Application no: H15/0122/96

Description: Proposed extension

Location: 14 Town Drove
Quadrang
Spalding
Lincs

Amendment: Revisions to recesses: window types and omit brick arches
to window openings

PROPOSED EXTENSION FOR :- MR. N. D. STANDAGE,
AT :- 14, TOWN DROVE, QUADRING

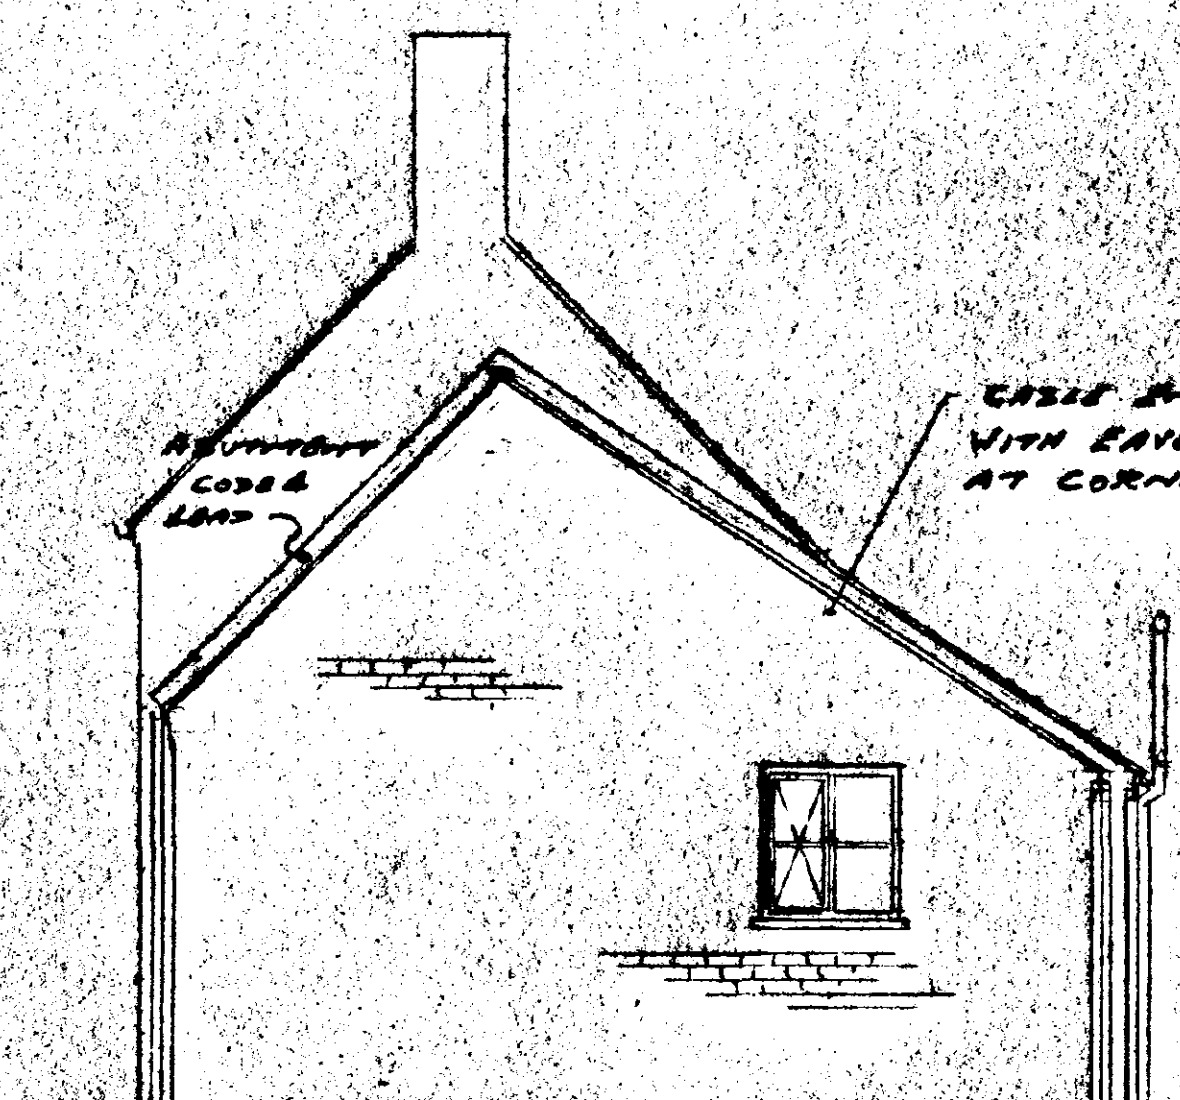
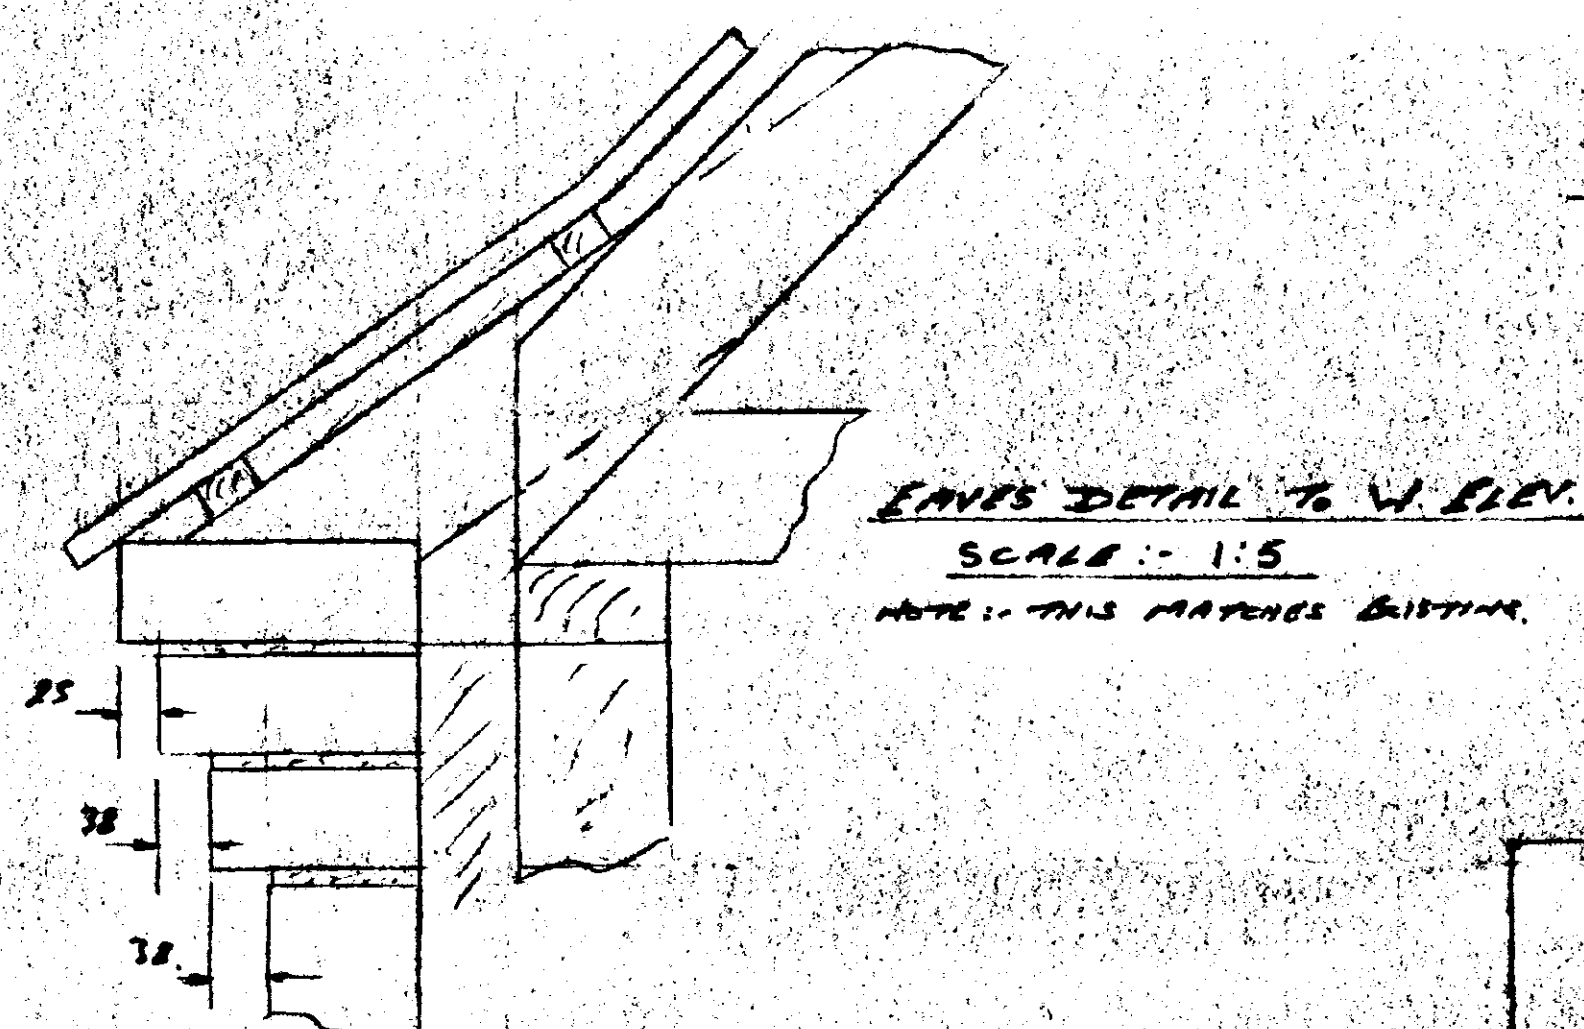
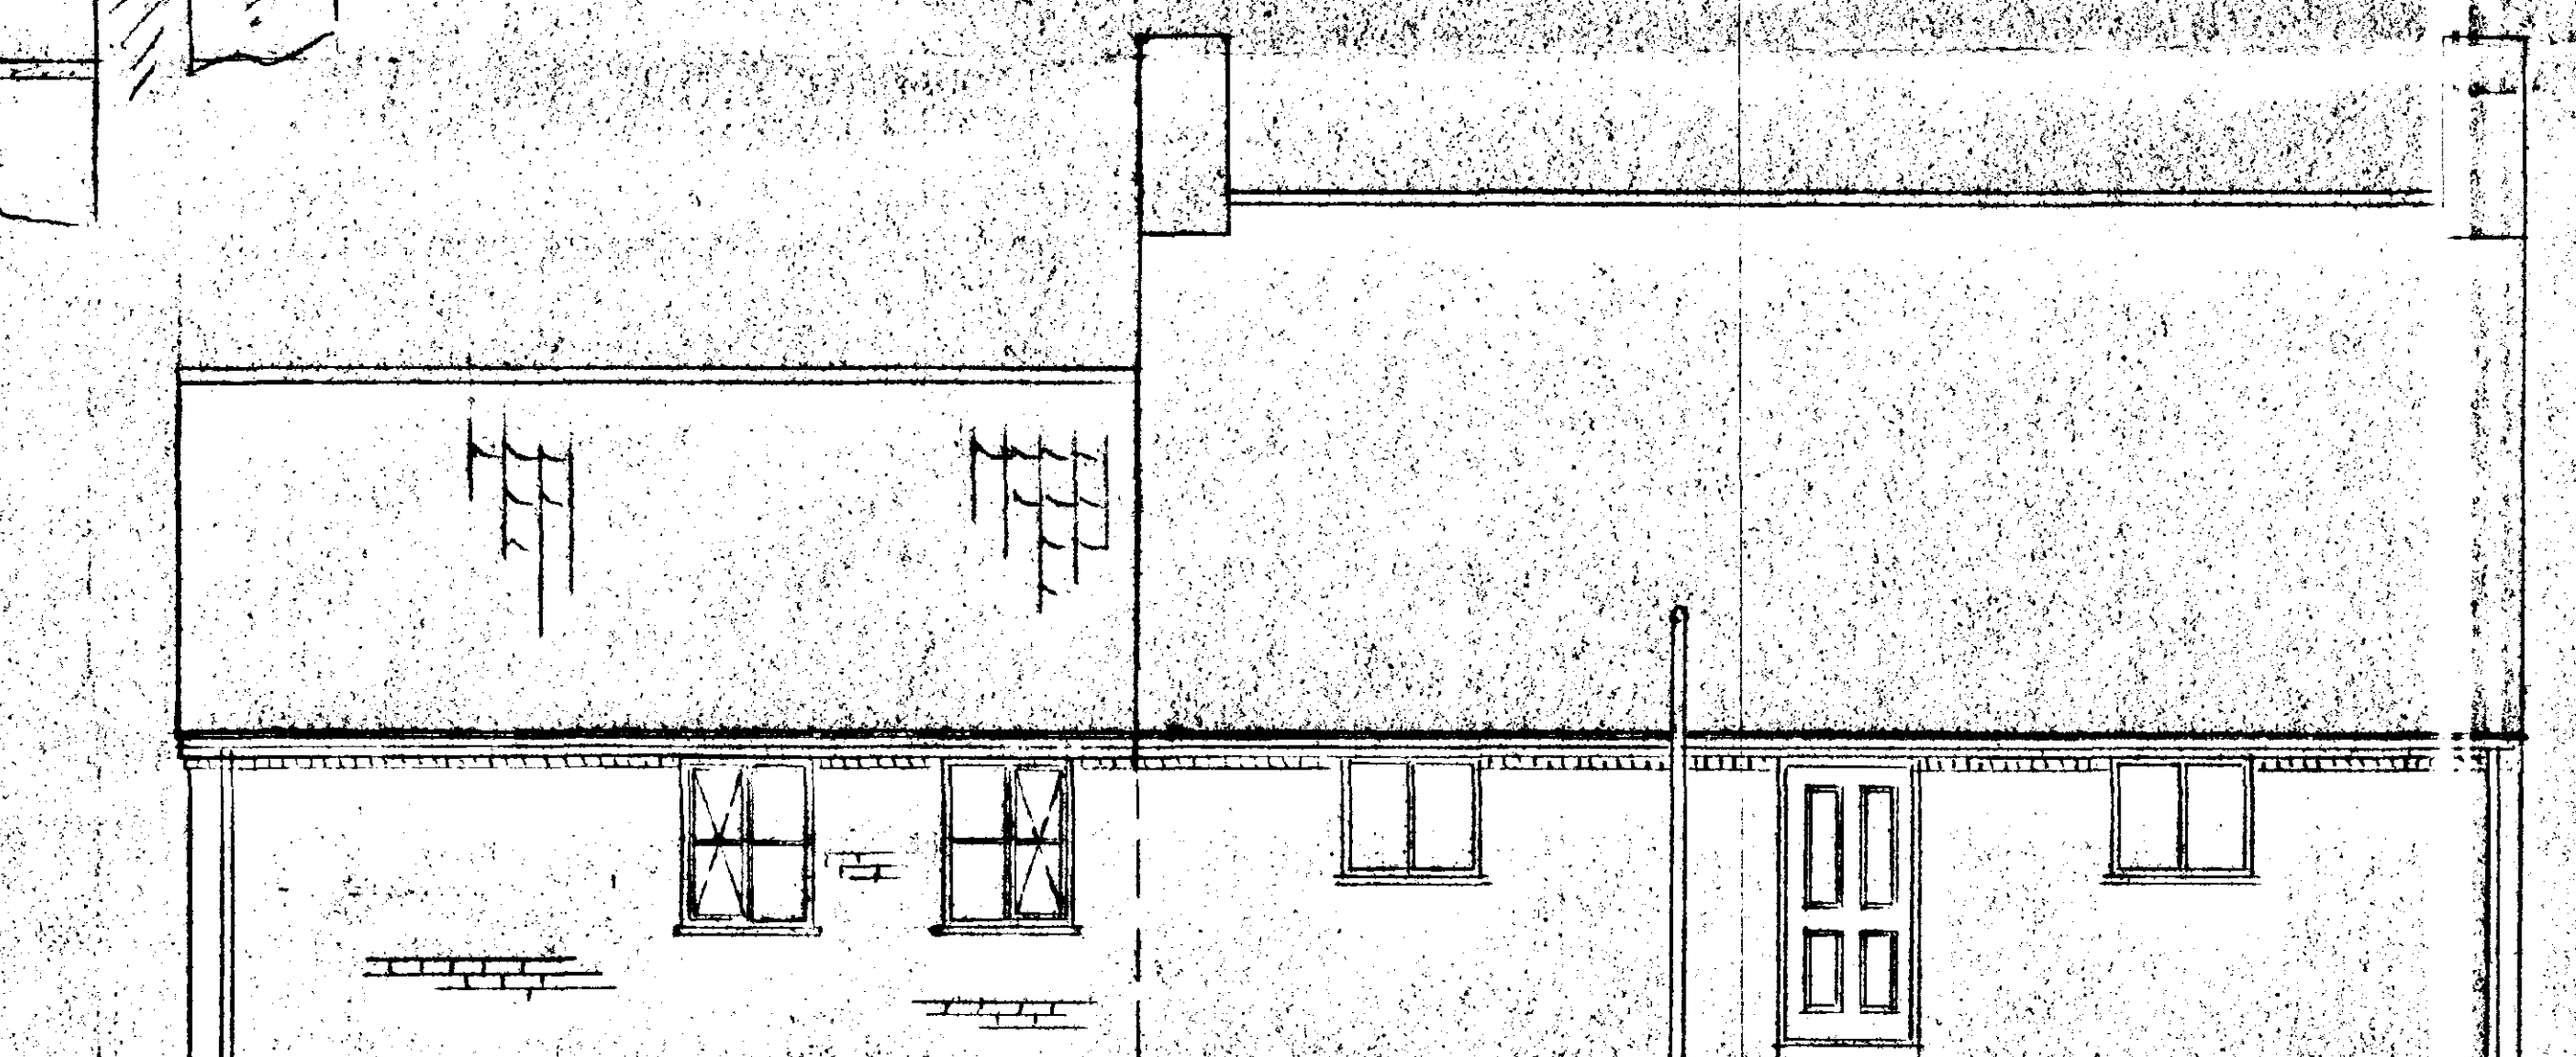
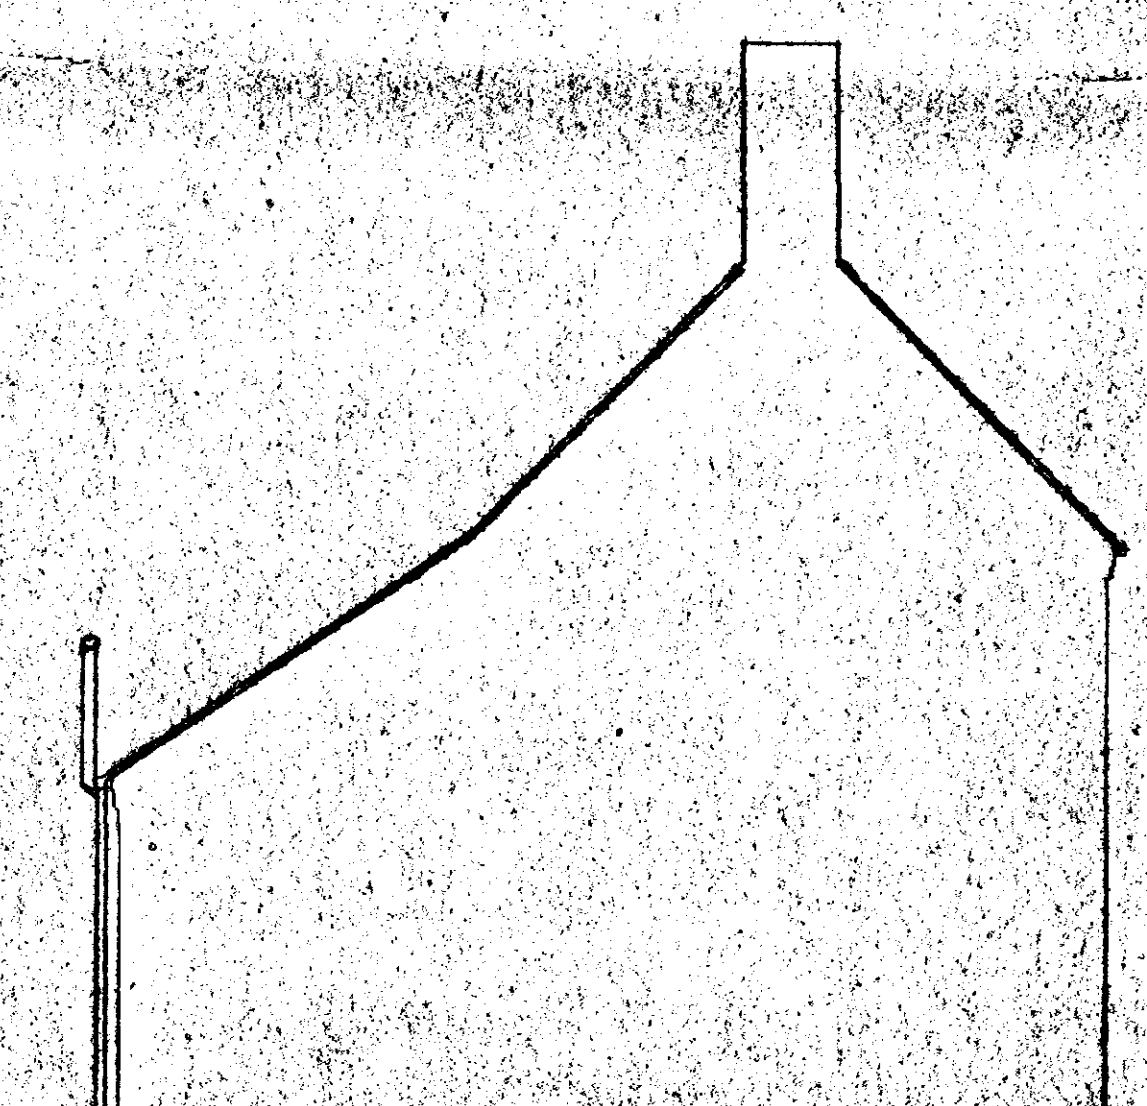
a) ALTER WINDOW / DOOR THRESHOLDS FROM 75MM TO 30MM
b) GENT BRICK ARCHES TO MATCHES + DOOR OF WEST ELEVATION
WHILE MAINTAINING BRICK PROFILE LEAVES DETAIL
TO MATCH EXISTING.
c) USE STANDARD TIMBER WINDOWS/DOORS BY JOHN CARL
d) STAGE RANGES WITH WHITE PINTED FINISH
e) EXISTENCE AS SHOWN ON ORIGINAL DRAWINGS AS
APPROVED BY MR. E. SCARVER (COUNCIL). DURING BED TO BE
0.915M WIDE x 2.2M DEEP (BATH) 0.915M WIDE x 1.05M
